**PUBLIC HEALTH DEPARTMENT**

April 10, 2008

RE: Sunset Farms Preliminary Plat (P-07-60)

**SITE PLAN  
OF  
SUNSET FARMS**

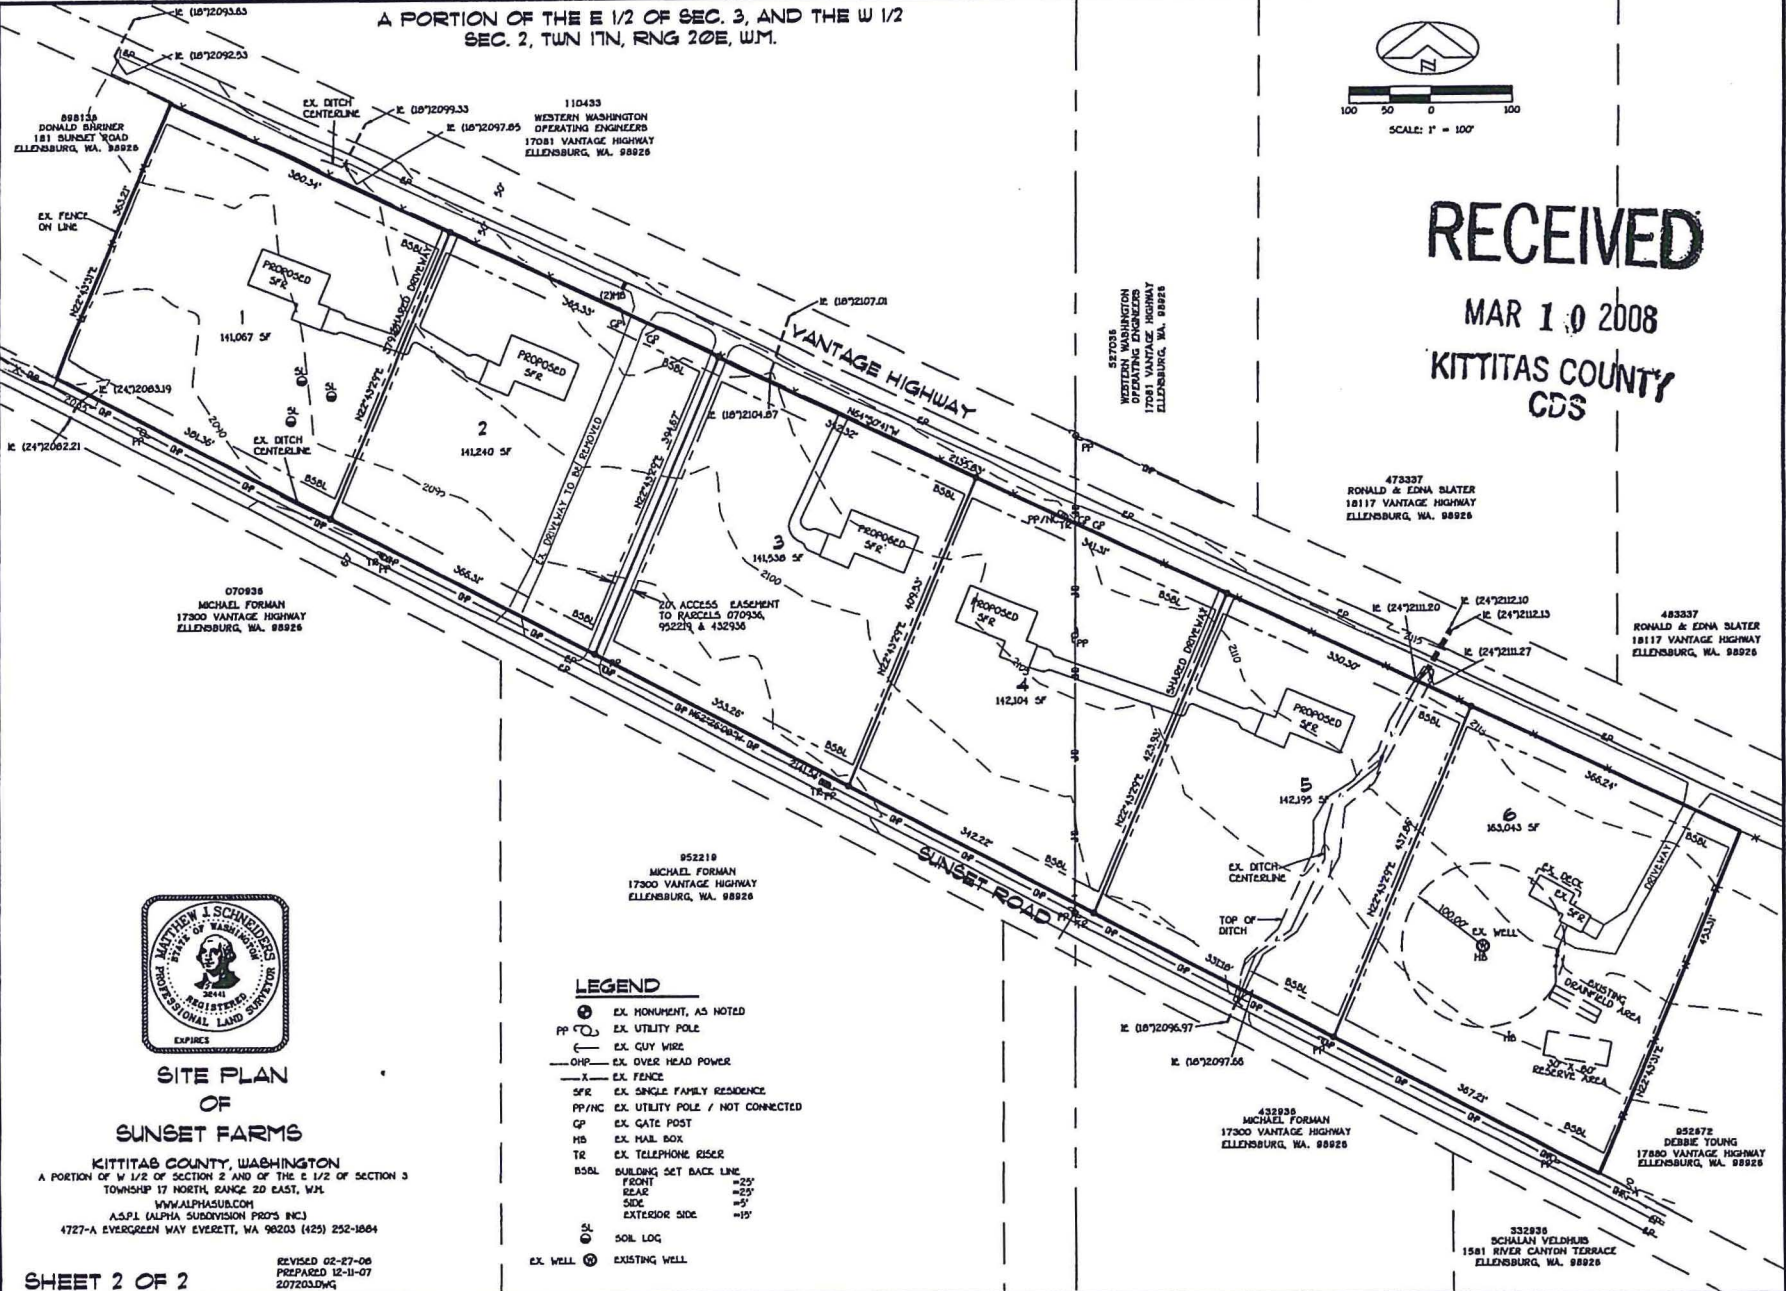
Thank you for the opportunity to comment on the above referenced project. I recommend that the existing well on lot 6 be approved as a Group B water system to serve all six proposed lots in this plat.

The file indicates soil log information is needed on each lot.

The water system plan and design will need to be submitted and approved prior to final plat approval.
